29 August 2008

NSW Department of Planning
Strategic Sites & Urban Renewal
Director Strategic Assessments - Mr Michael File
GPO Box 39,
SYDNEY, NSW, 2001

**Part 3A - Project Application (Application No. MP 07_0099)
Potts Hill Sydney Water Redevelopment by Landcom (Bankstown LGA)**

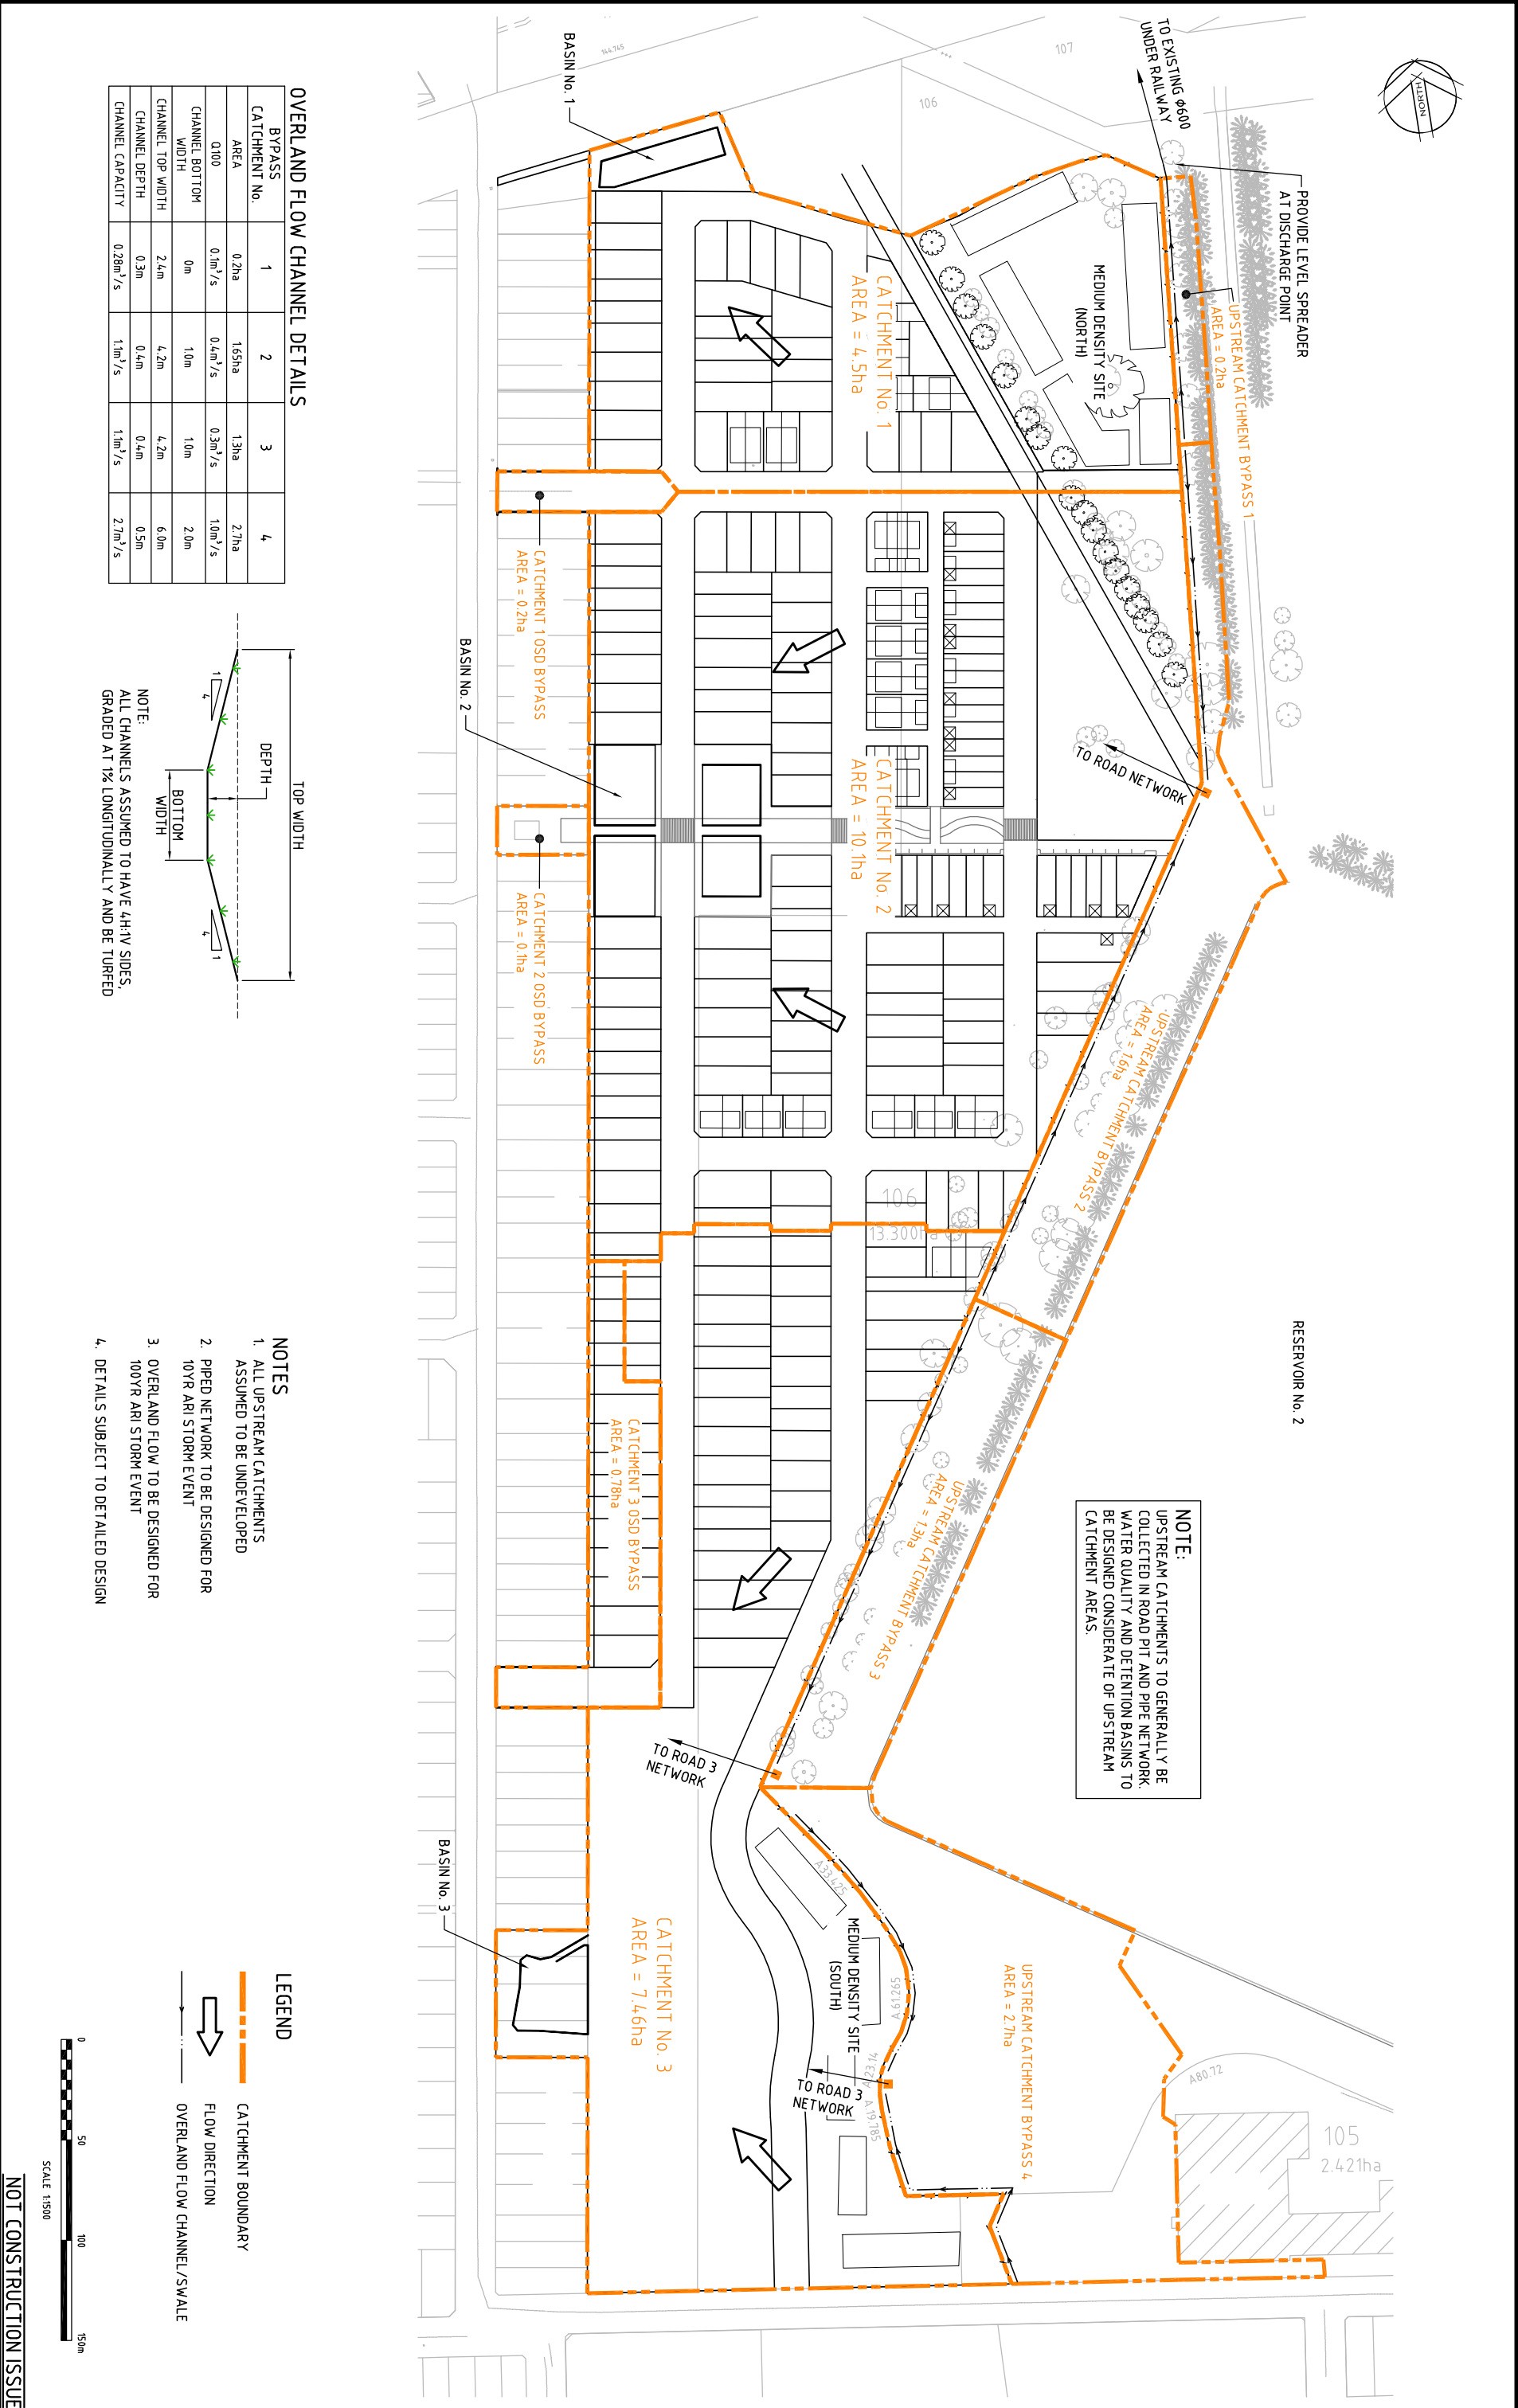
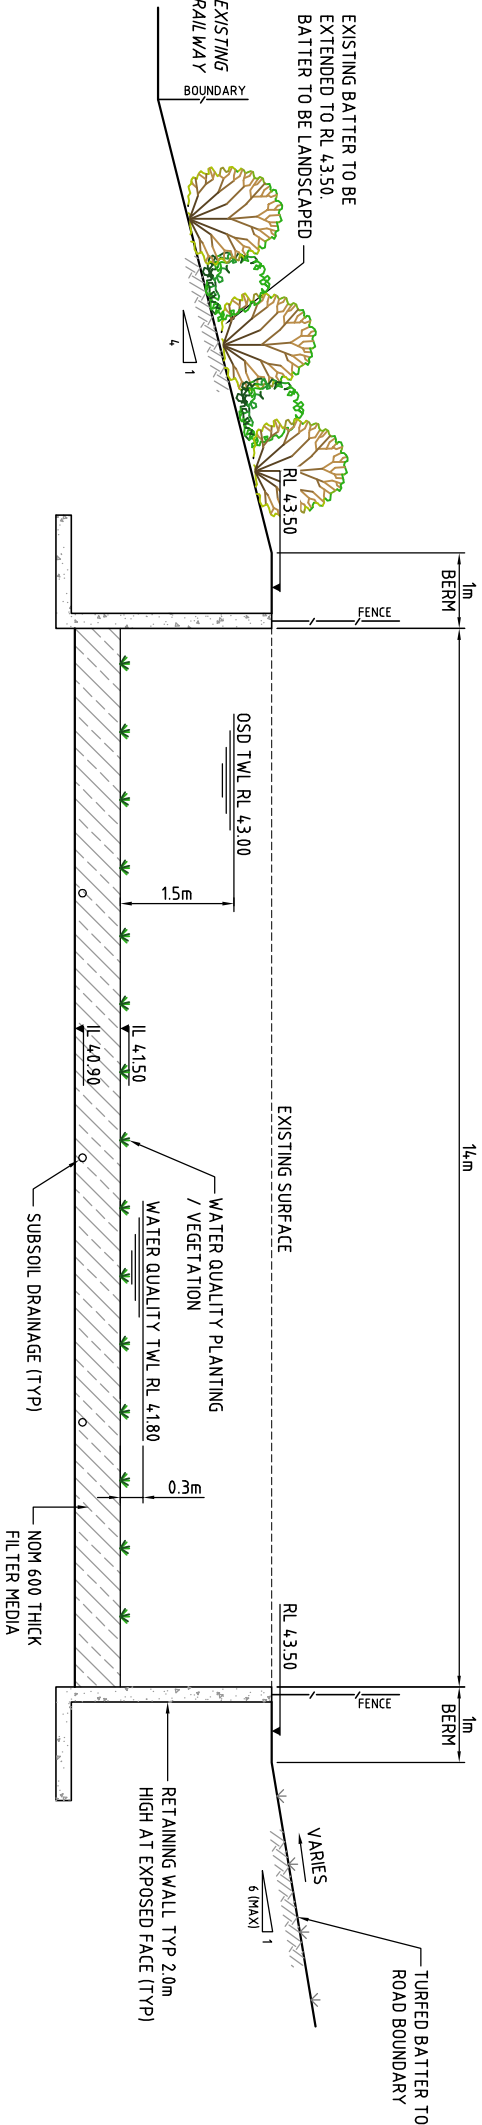
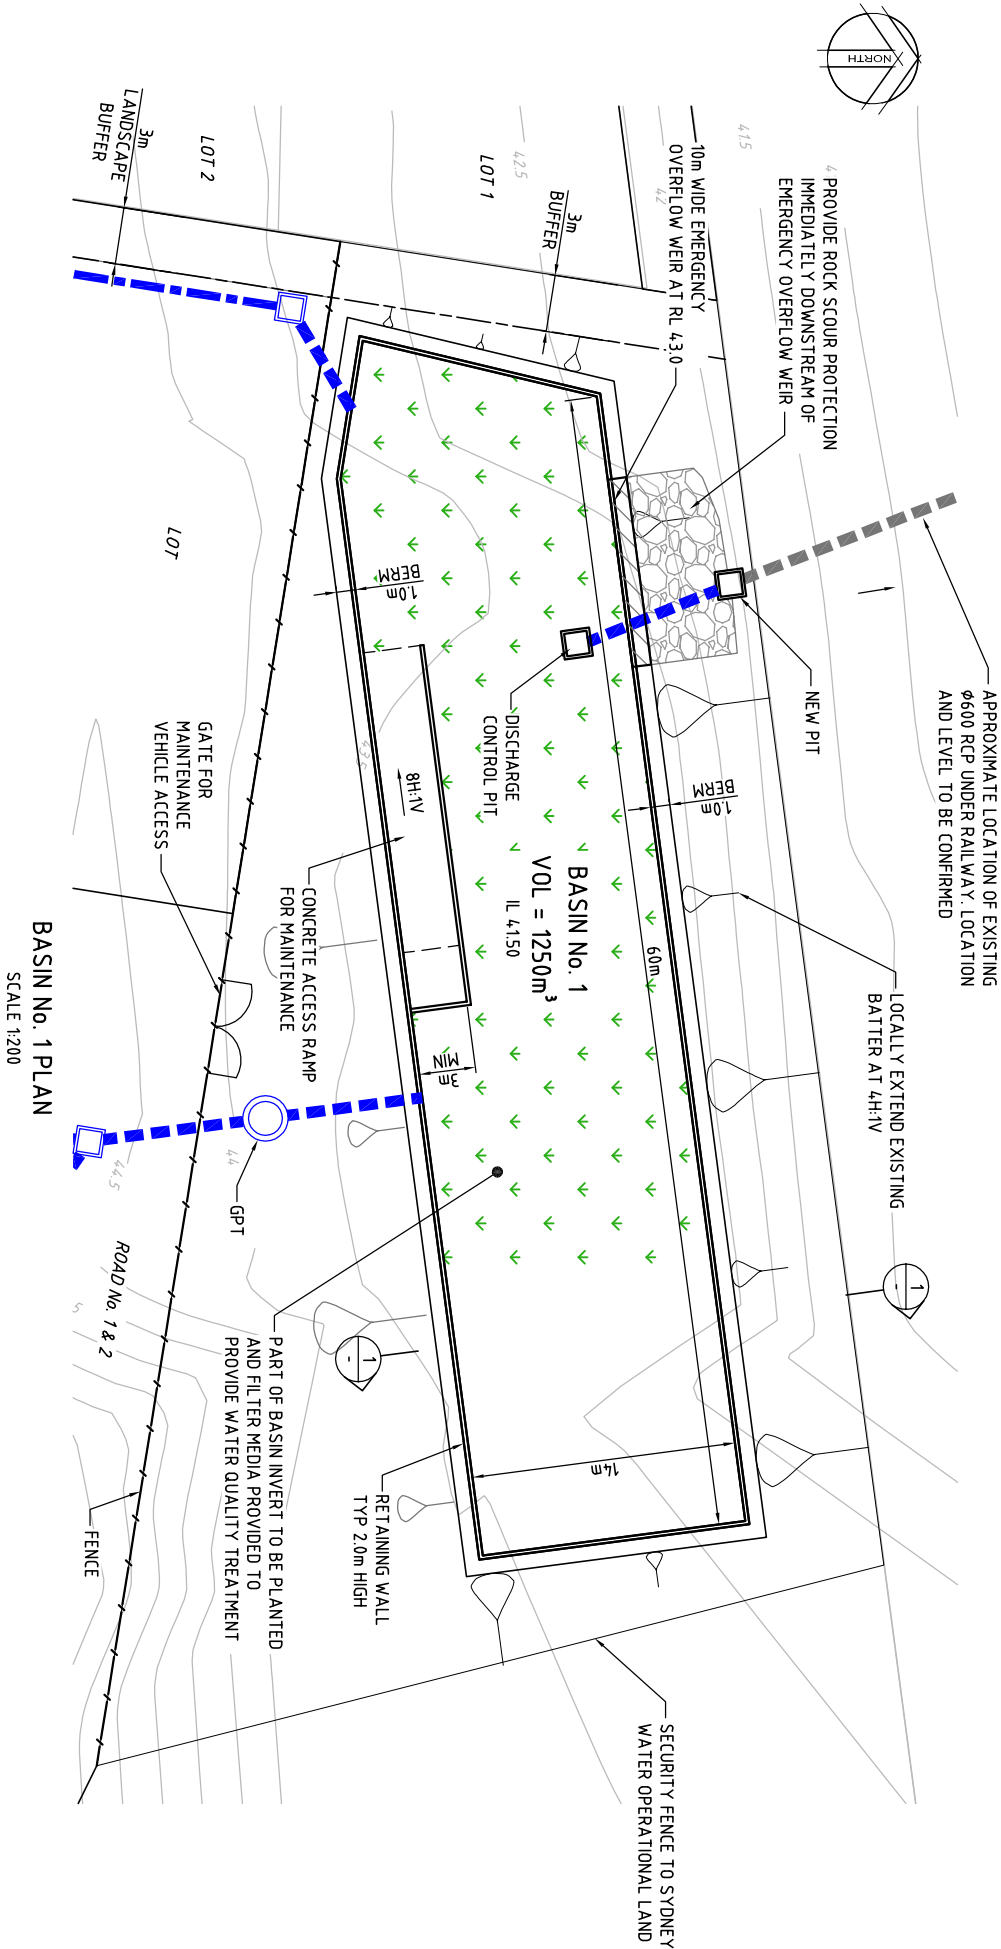
2.2.5 Council encourages innovative design, however the construction of swales in the road design will result in additional maintenance costs to Council, when the roads are transferred to Council. Council would suggest that Landcom enter into a Planning Agreement which details how the swales will be managed and maintained

- 6.3 Council raises concern over the use of parklands as permanent stormwater retention basins, and the associated long-term management and maintenance issues. The use of these retention basins for short-term stormwater events is suitable, however long term ponding of water in these localities would be a burden on Council resources and health concerns.
